**WEST SUSSEX COUNTY COUNCIL
STRATEGIC PLANNING CONSULTATION**

SUBJECT: LU/121/17/RES - Approval of reserved matters following outline consent LU/47/11/ for construction of 126 No. dwellings together with internal road network, car parking & landscaping.

LOCATION: Land North of, Toddington Lane, C1 & part Parcels B2, B4 & C2, Littlehampton, West Sussex, BN17 7PP.

This is the second WSCC highways and transport response to the above planning application and responds to the additional information provided by the applicant. Drainage comments will again be made separately by the drainage engineer.

Tree planting along Main Avenue - Plan
Scale 1:50

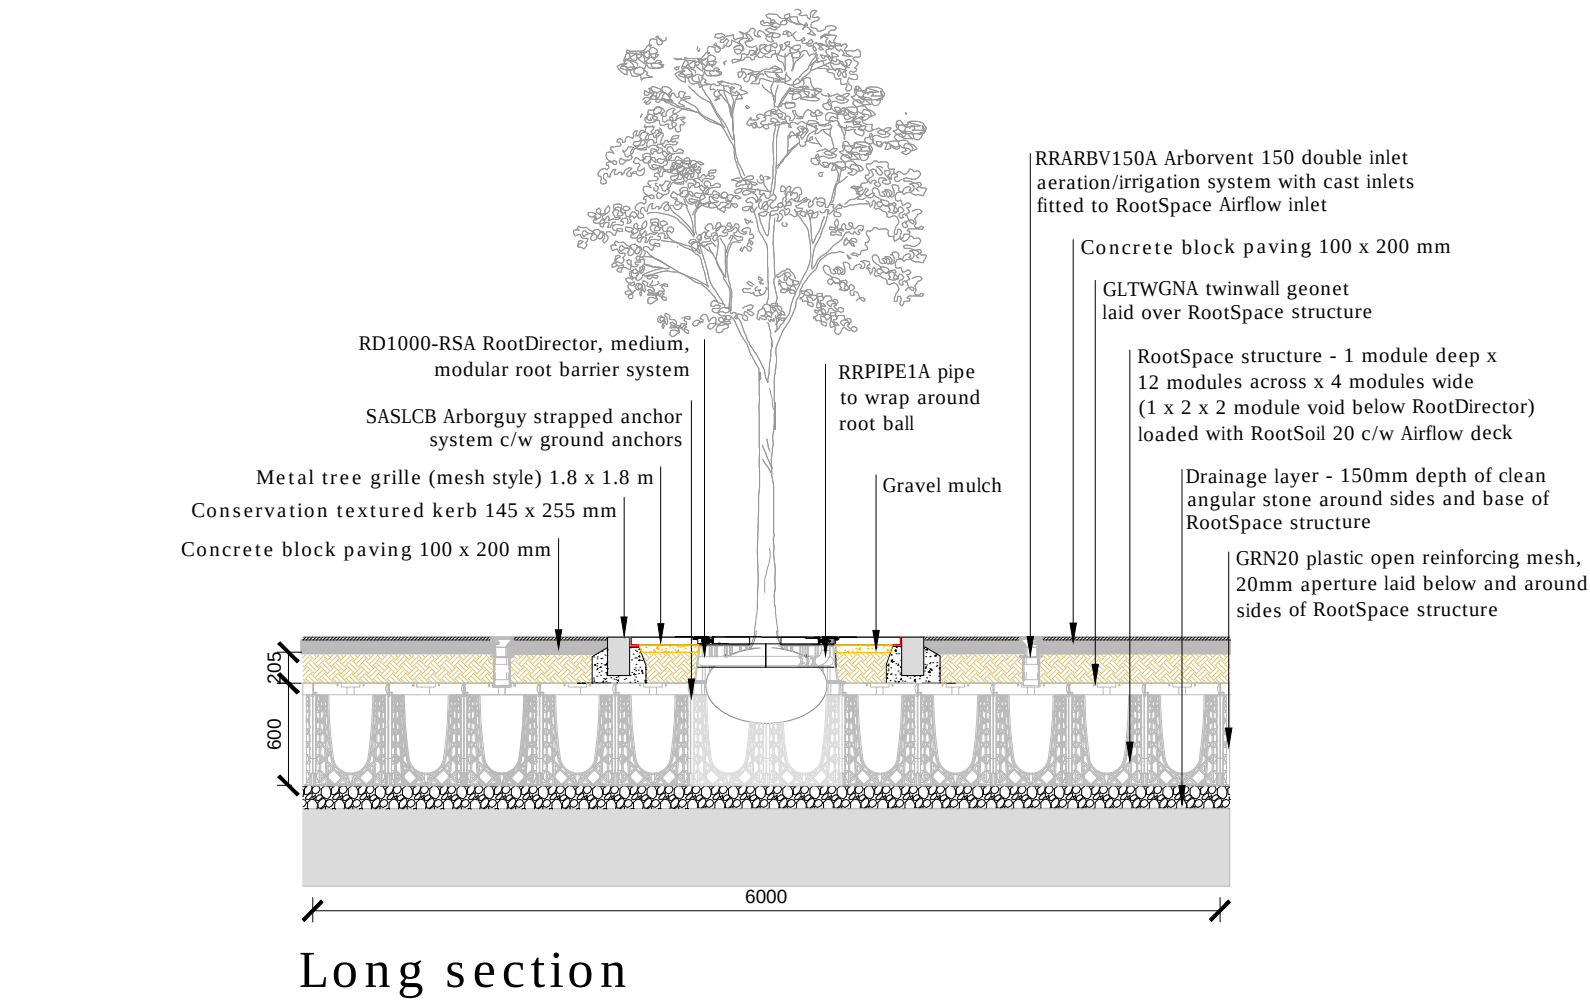
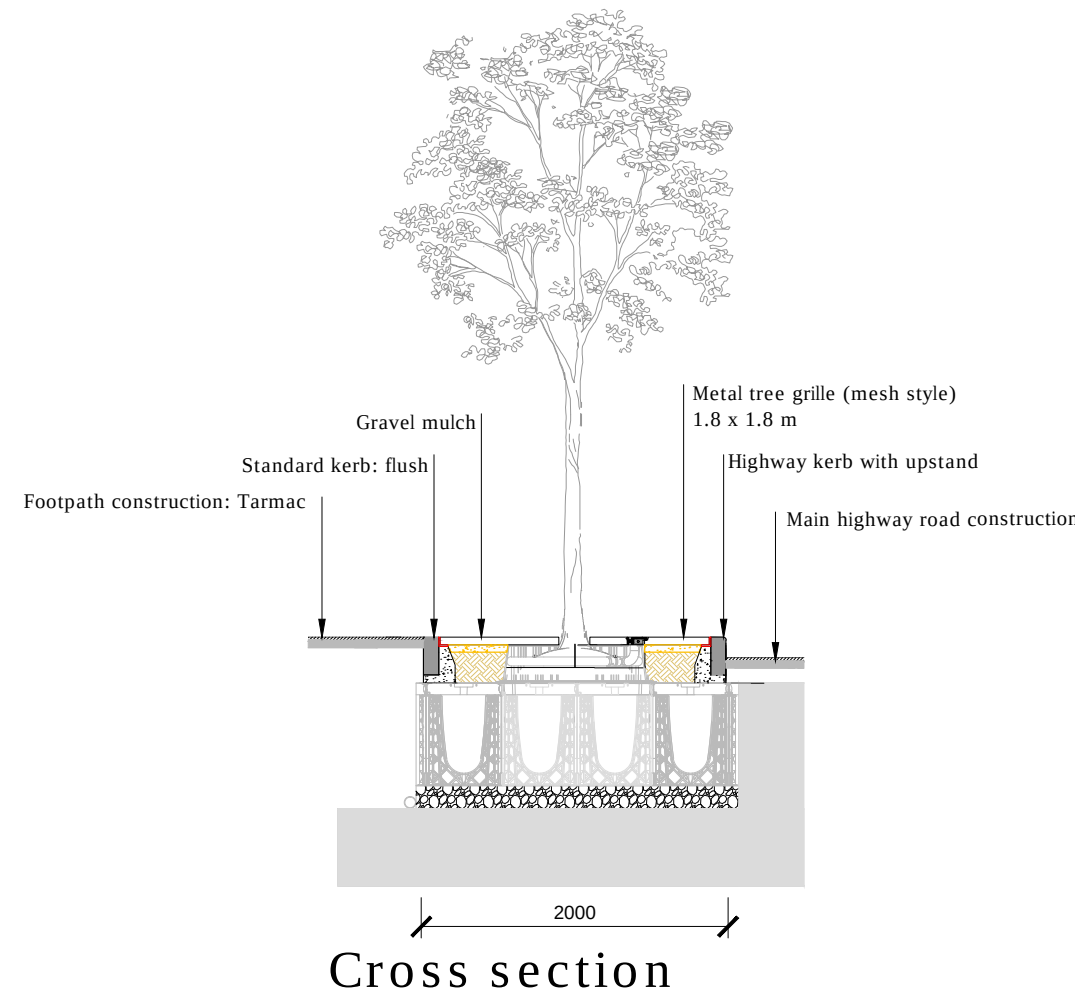
With regard to hard landscaping (granite setts with trees pits adjacent are shown for parts of the main spine road leading into the development from the IDR), this type of treatment should be removed and replaced with grass. Granite setts are potentially a safety hazard if pedestrians choose to cross over them, a maintenance liability and can create issues with tree growth adjacent.
